**PLANNING DEPARTMENT
DEVELOPMENT SERVICES DIVISION
600 2nd Street NW, Ground Floor, 87102
P.O. Box 1293, Albuquerque, NM 87103
Office (505) 924-3946**

OFFICIAL NOTIFICATION OF DECISION

Project# PR-2021-005371
Application#
SD-2021-00186 PRELIMINARY/FINAL PLAT

LOTS 5 & 6, UTE ADDITION zoned R-1D,
located at **3534 & 3536 UTE RD NW**
between 50TH ST NW and 47TH ST NW
containing approximately 0.2824 acre(s).
(K-11)

**Site Sketch for
Lot 5-A and 6-A,
Ute Addition
Being Comprised of
Lots 5 and 6, Ute Addition
City of Albuquerque
Bernalillo County, New Mexico
August 2021**

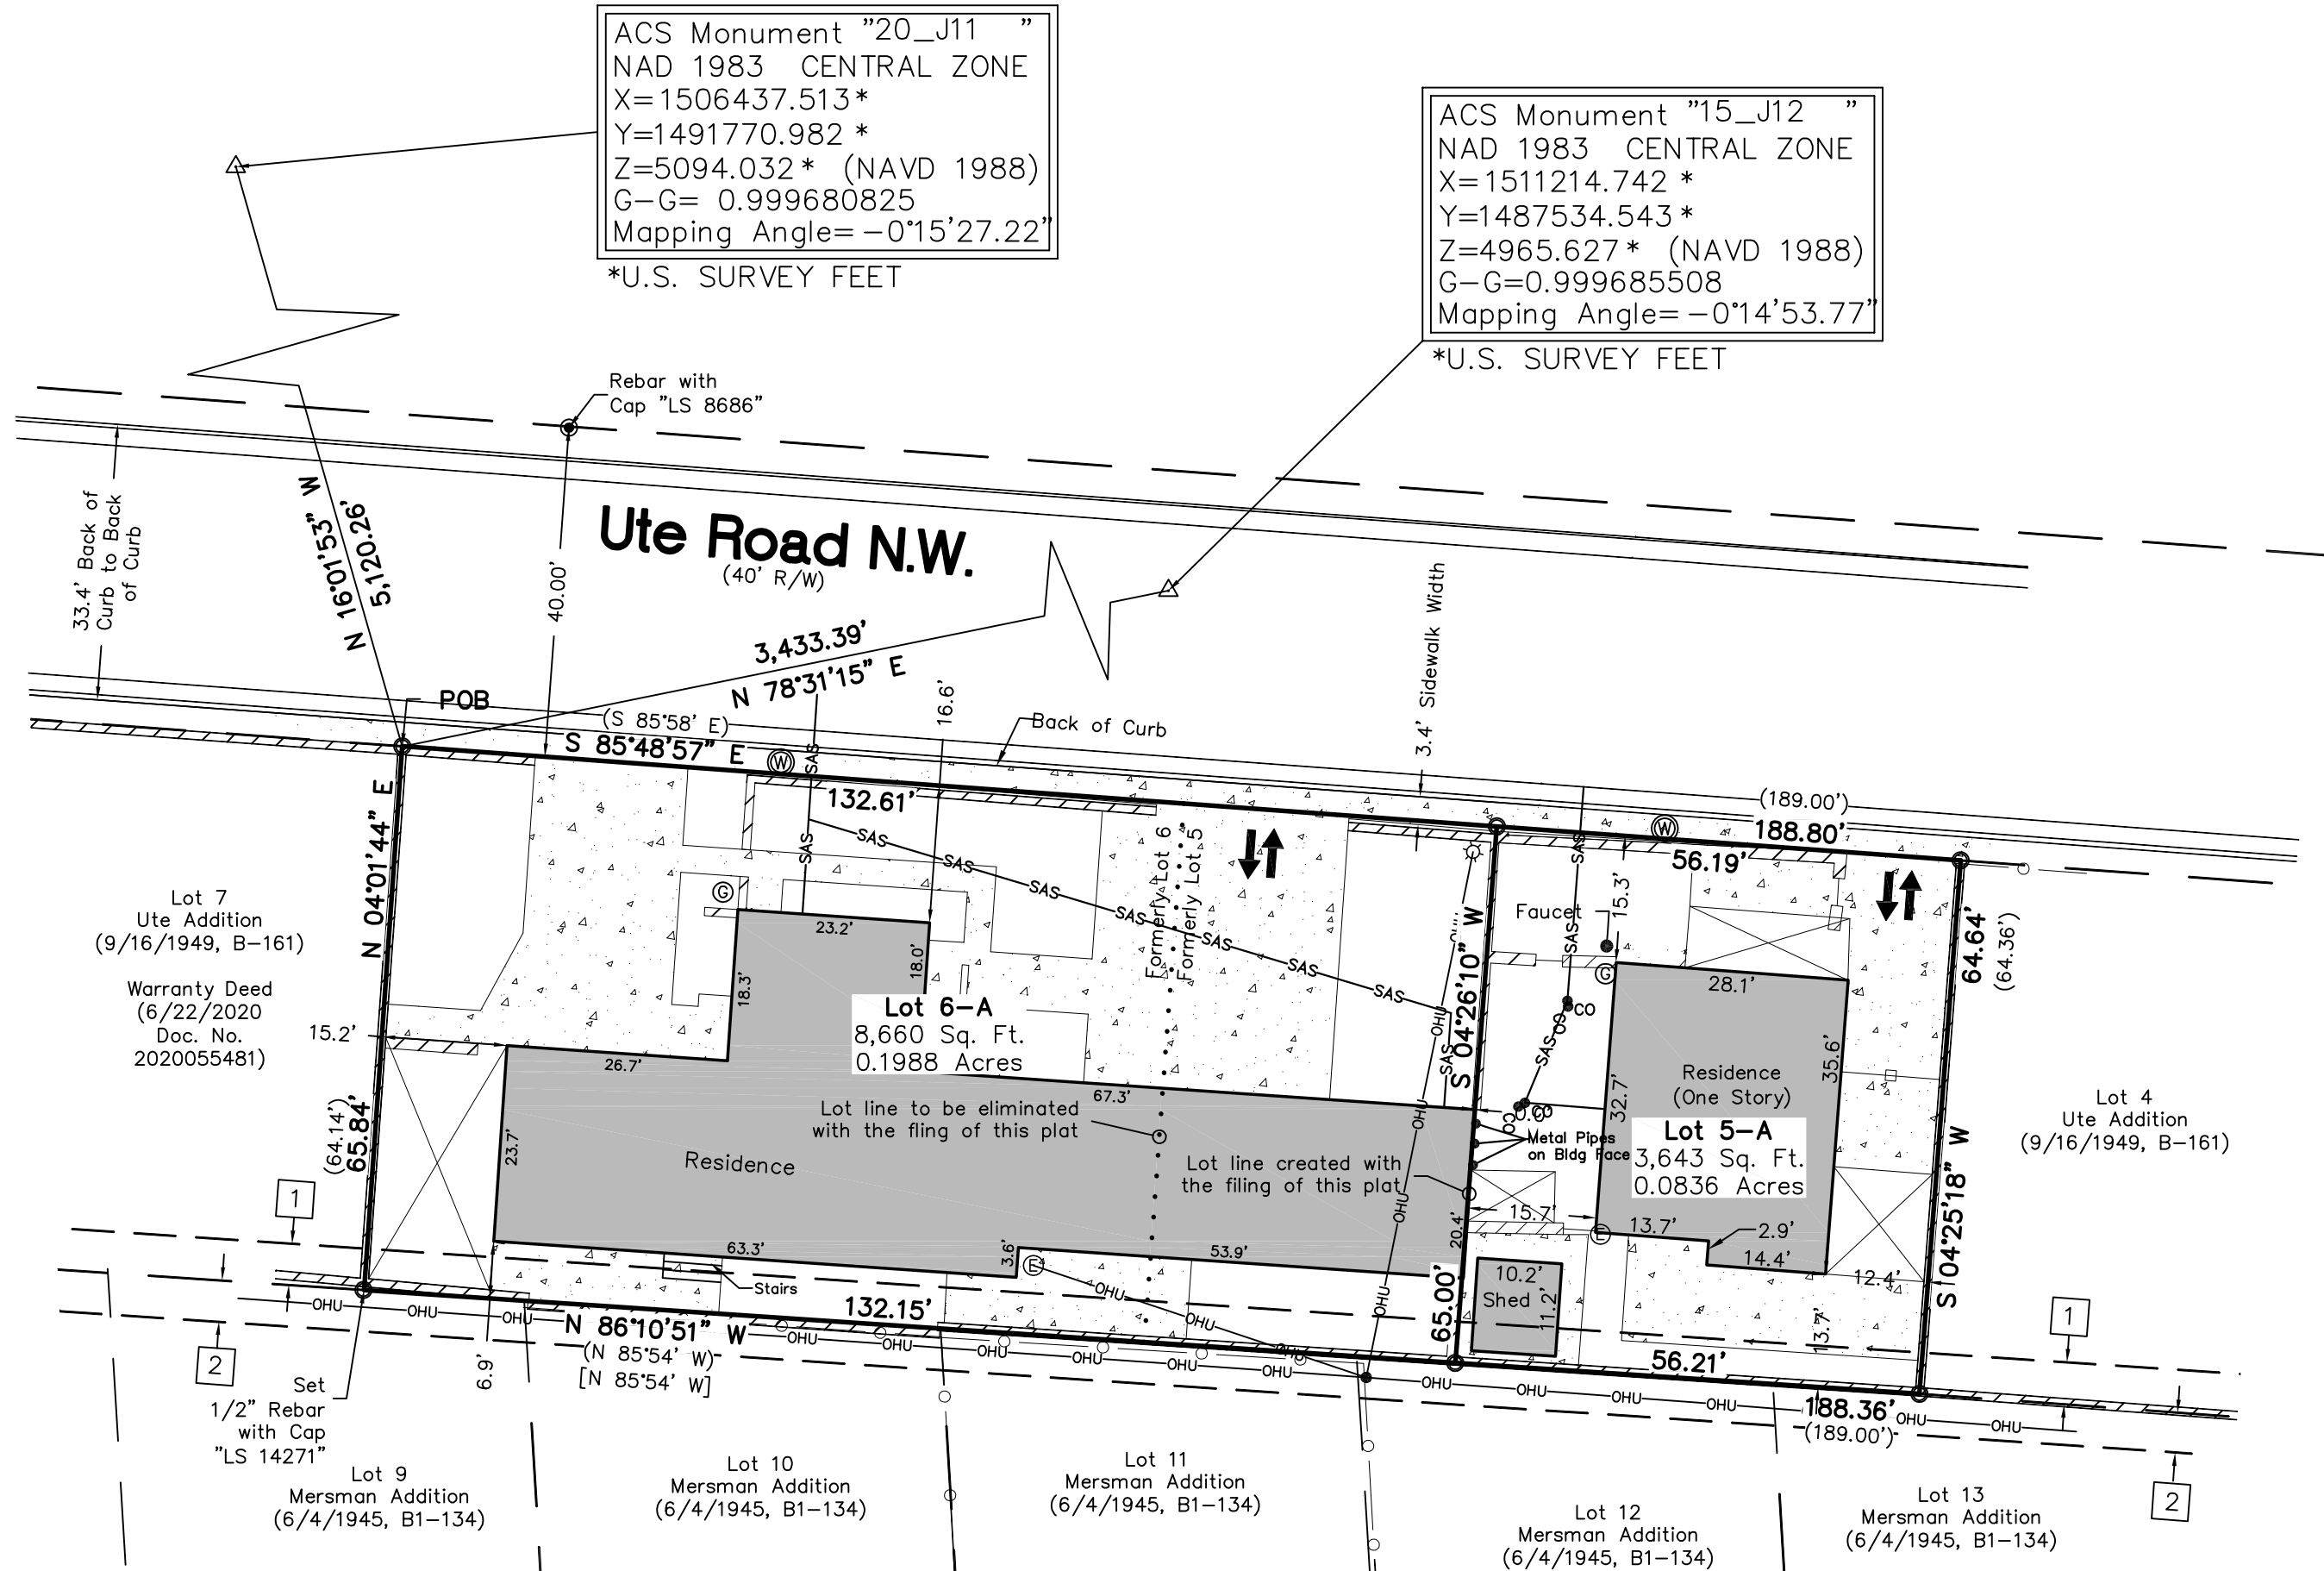
1. Final sign-off is delegated to Transportation for an exhibit showing site distance triangles as well as the amount of wall removal needed around accessways to address site distance issues.
2. Final sign-off is delegated to Planning for the AGIS DXF file.
